Great North Road Solar and Biodiversity Park

Draft Statement of Common Ground with Nottinghamshire County Council

Document reference – EN010162/APP/8.4A1B

~~January~~February 2026

**Breeding Bird Survey Results  
Amber-Listed Species  
Figure A8.4.1 SE**

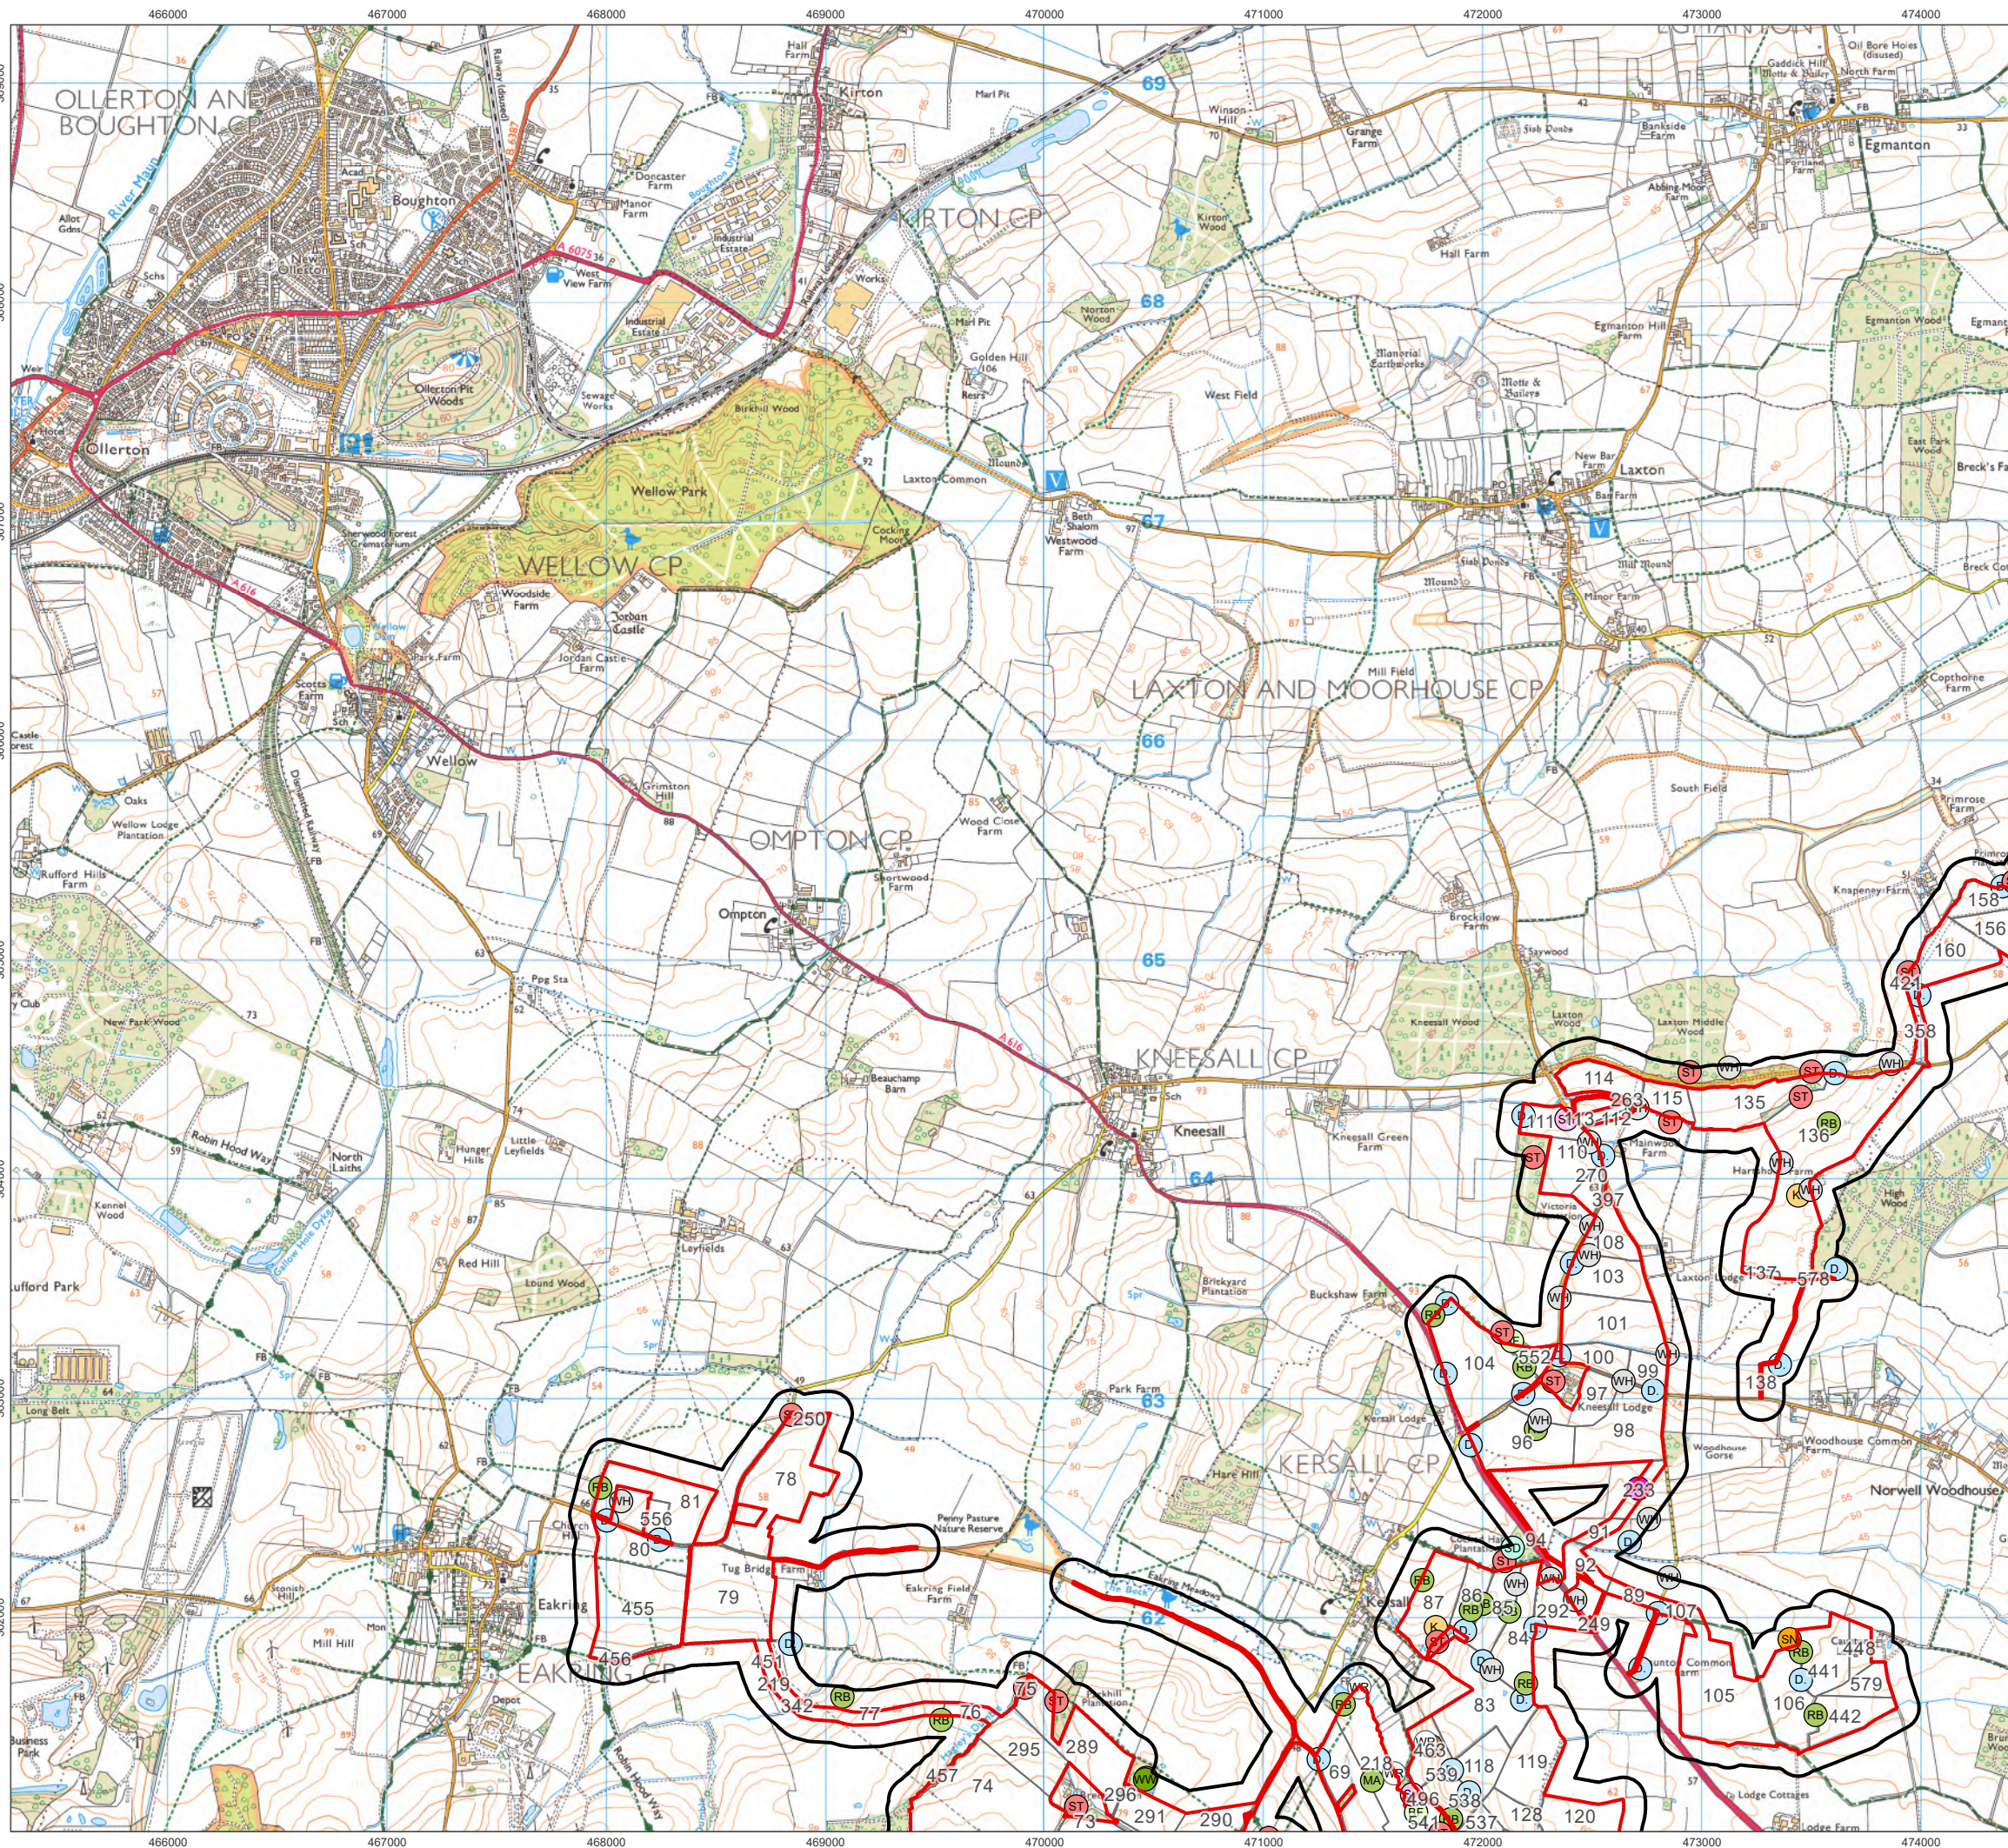
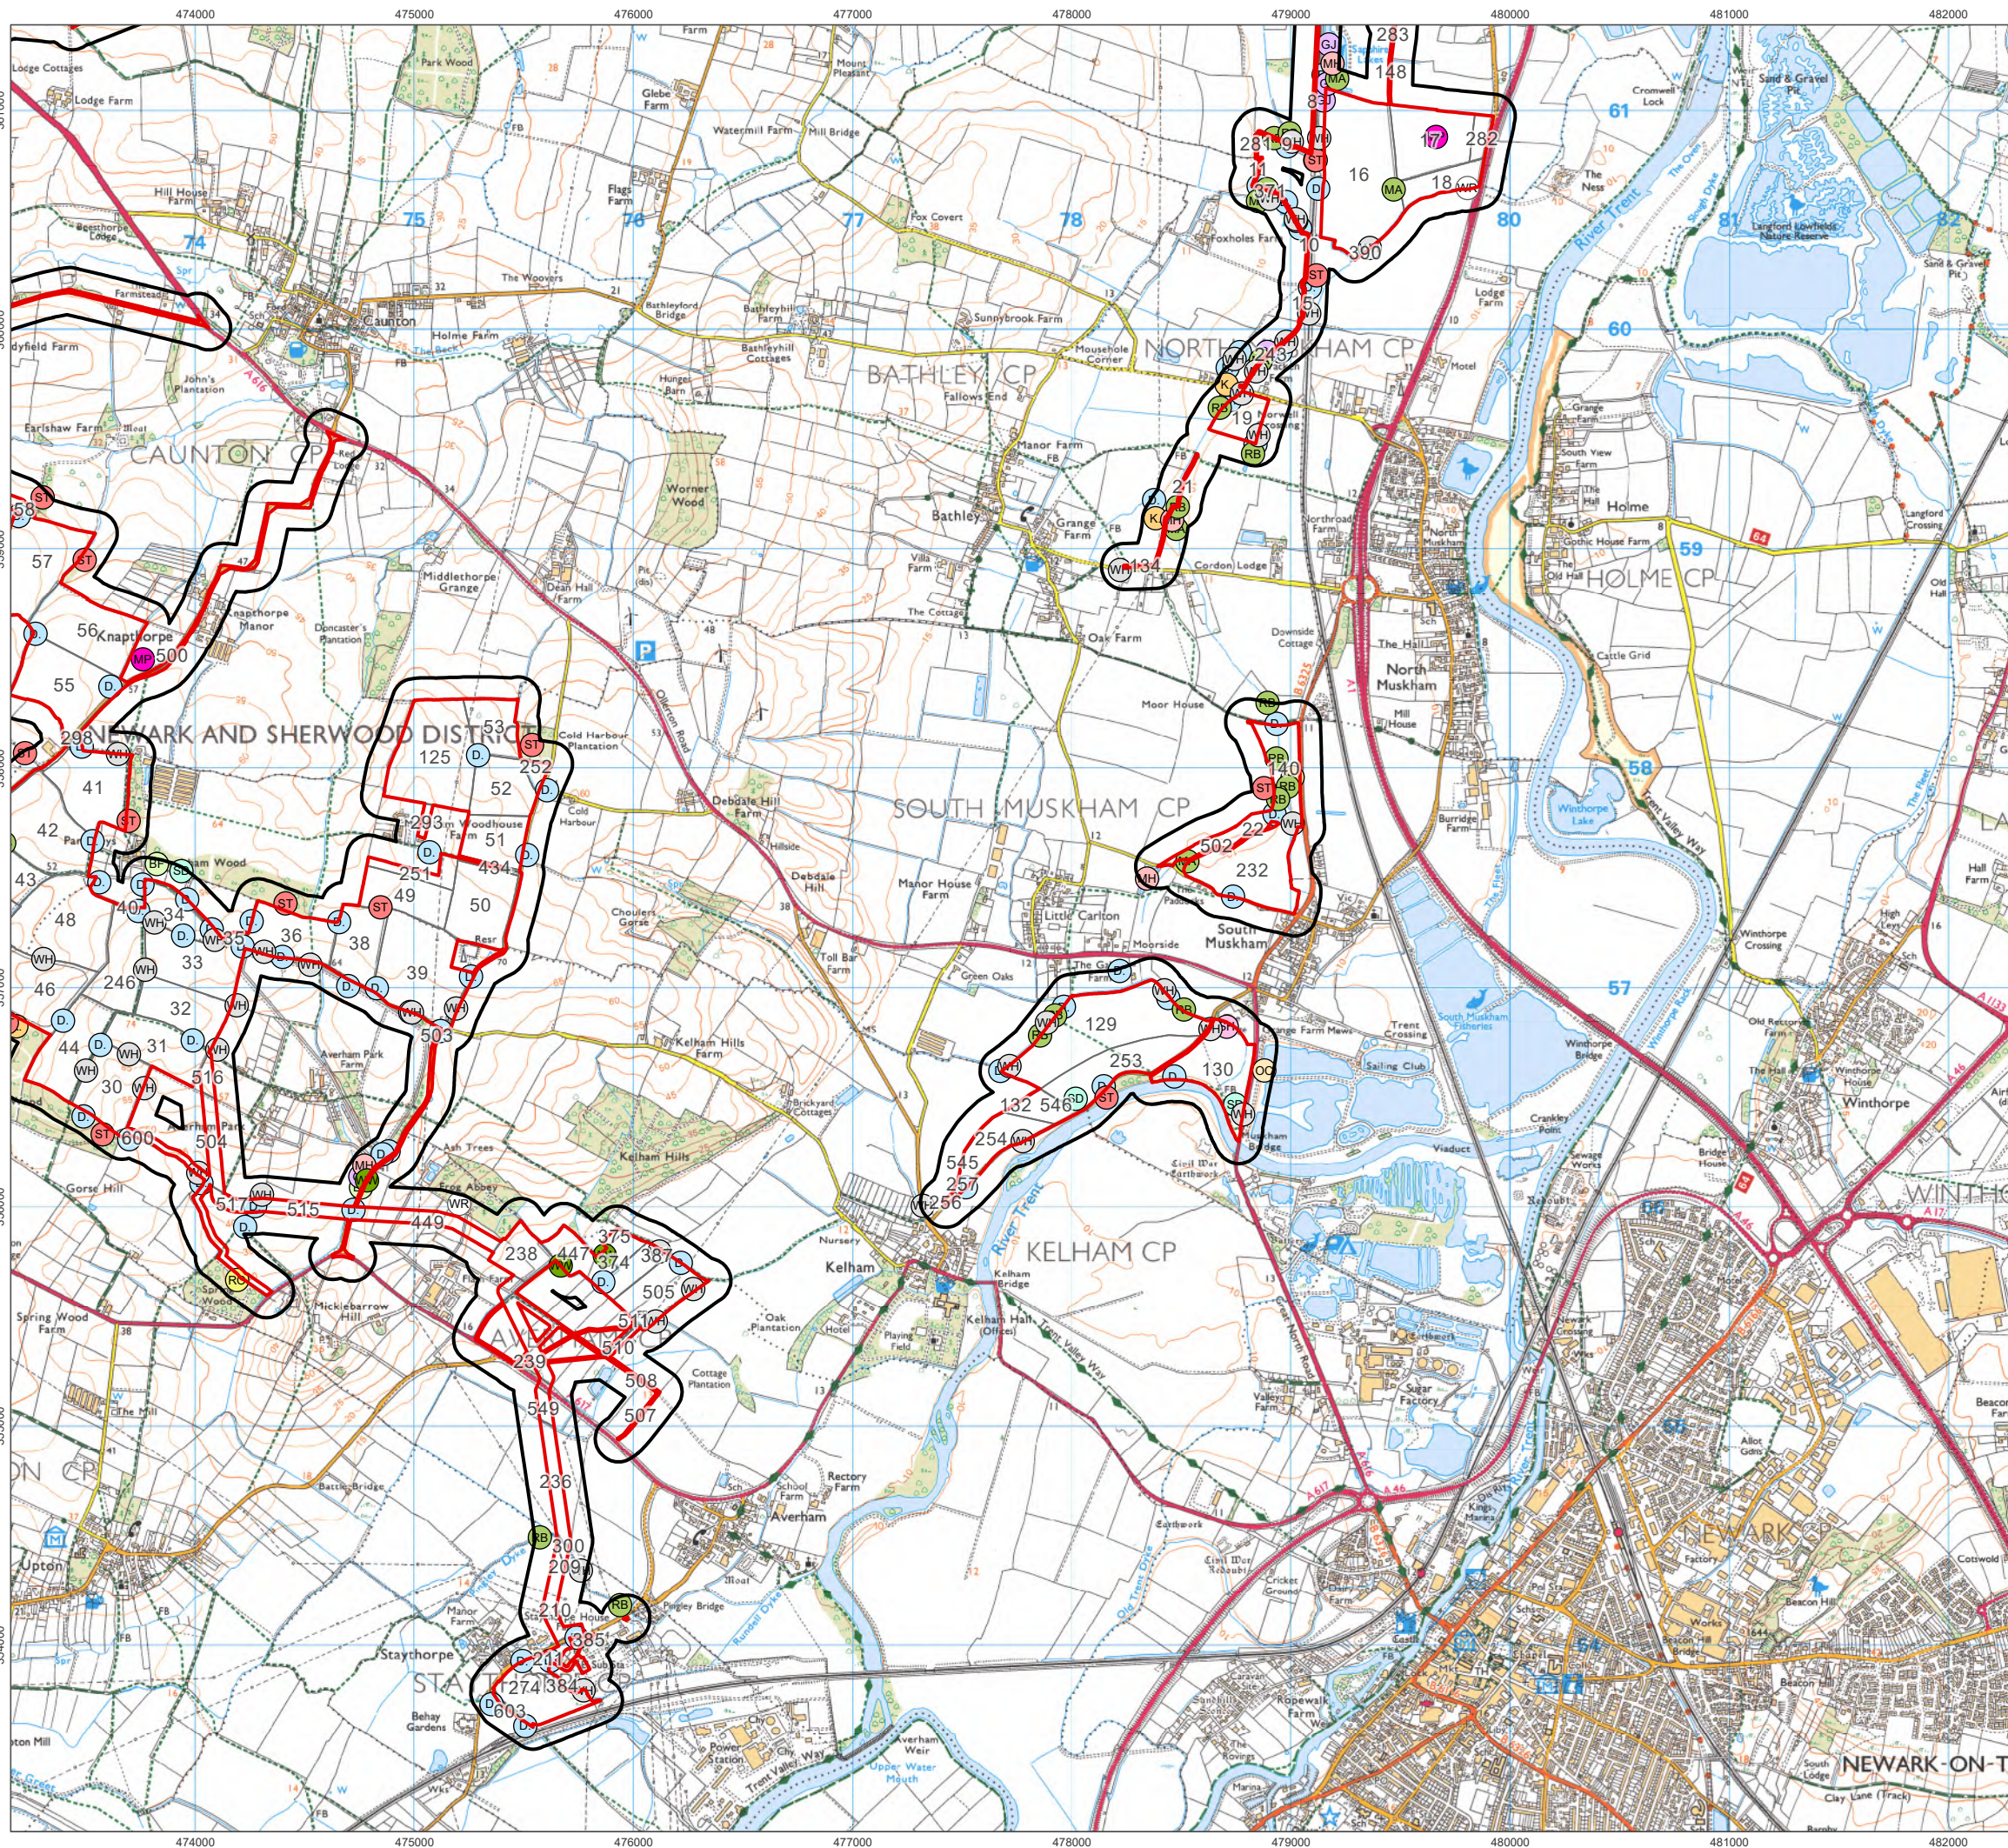
Ref	Relevant Documents	Description of Matter	Applicant's <u>NCC's</u> Position	<u>NCC's</u> Applicant's Position	Status
			<p><u>further comments on receipt of this information from the applicant.</u> <u>Our main queries prior to this are:</u> <u>Were specific nightjar and other crepuscular species surveys undertaken, given the sites location within Sherwood Forest ppSPA.</u> <u>The ES chapter claims the surveys were undertaken in line with best practice guidelines and references, but this survey methodology requires a minimum of 6 surveys, and not four which the applicant has undertaken. In addition, this survey methodology also states: "Any deviation in the number of surveys must be supported with detailed and robust justification. Additional survey effort may need to be considered for large-scale projects with the potential to have significant impacts on birds, and/or for high profile, sensitive projects". Further justification for the level of survey effort undertaken is therefore sought.</u> <u>The site has been assessed as regional value to breeding birds</u></p>	<p><u>engagement since Deadline 1 to resolve this issue.</u></p> <p><u>Deadline 2 Position:</u> <u>The baseline studies and survey methods for breeding birds are presented in ES Volume 4, Appendix A8.4: Breeding Birds Baseline [EN010162/APP/6.4.8.4] [APP-217]. Section A8.4.2.2 (paragraph 24) provides justification for the survey methods and section A8.4.2.4 describes potential limitations and how these have been addressed.</u> <u>An assessment of the effects of the Development on breeding birds is provided in section 8.9.10 of ES Volume 2, Chapter 8: Ecology and Biodiversity [EN010162/APP/6.2.8] [APP-051].</u> We have not had sight of the breeding bird survey results appendix and therefore will provide further comments on receipt of this information from the applicant. Our main queries prior to this are:</p>

Ref	Relevant Documents	Description of Matter	Applicant's <u>NCC's</u> Position	<u>NCC's</u> Applicant's Position	Status
			<p><u>with SPI, LBAP, LWS- qualifying species and Schedule 1 WCA species recorded. Should further analysis of this be undertaken given the potential qualification of a LWS feature. The baseline studies and survey methods for breeding birds are presented in ES Volume 4, Appendix A8.4: Breeding Birds Baseline [EN010162/APP/6.4.8.4] [APP-217]. Section A8.4.2.2 (paragraph 24) provides justification for the survey methods and section A8.4.2.4 describes potential limitations and how these have been addressed.</u></p> <p><u>An assessment of the effects of the Development on breeding birds is provided in section 8.9.10 of ES Volume 2, Chapter 8: Ecology and Biodiversity [EN010162/APP/6.2.8] [APP-051].</u></p>	<p>Were specific nightjar and other crepuscular species surveys undertaken, given the sites location within Sherwood Forest ppSPA.</p> <p>The ES chapter claims the surveys were undertaken in line with best practice guidelines and references, but this survey methodology requires a minimum of 6 surveys, and not four which the applicant has undertaken. In addition, this survey methodology also states: "Any deviation in the number of surveys must be supported with detailed and robust justification. Additional survey effort may need to be considered for large scale projects with the potential to have significant impacts on birds, and/or for high profile, sensitive projects". Further justification for the level of survey effort undertaken is therefore sought.</p> <p>The site has been assessed as regional value to breeding birds with SPI, LBAP, LWS- qualifying species and Schedule 1 WCA</p>

2.1.3	RR	Protected Species - Breeding Birds	<p><u>Current Position:</u> <u>TBC</u></p> <p><u>Deadline 2 Position:</u> <u>We have not had sight of the breeding bird survey results appendix and therefore will provide</u></p>	<p><u>Current Position:</u> <u>The Applicant notes that the NCC comment has not been updated, but understands that NCC Officers have confirmed agreement on this matter. This follows ongoing</u></p>	Agreed
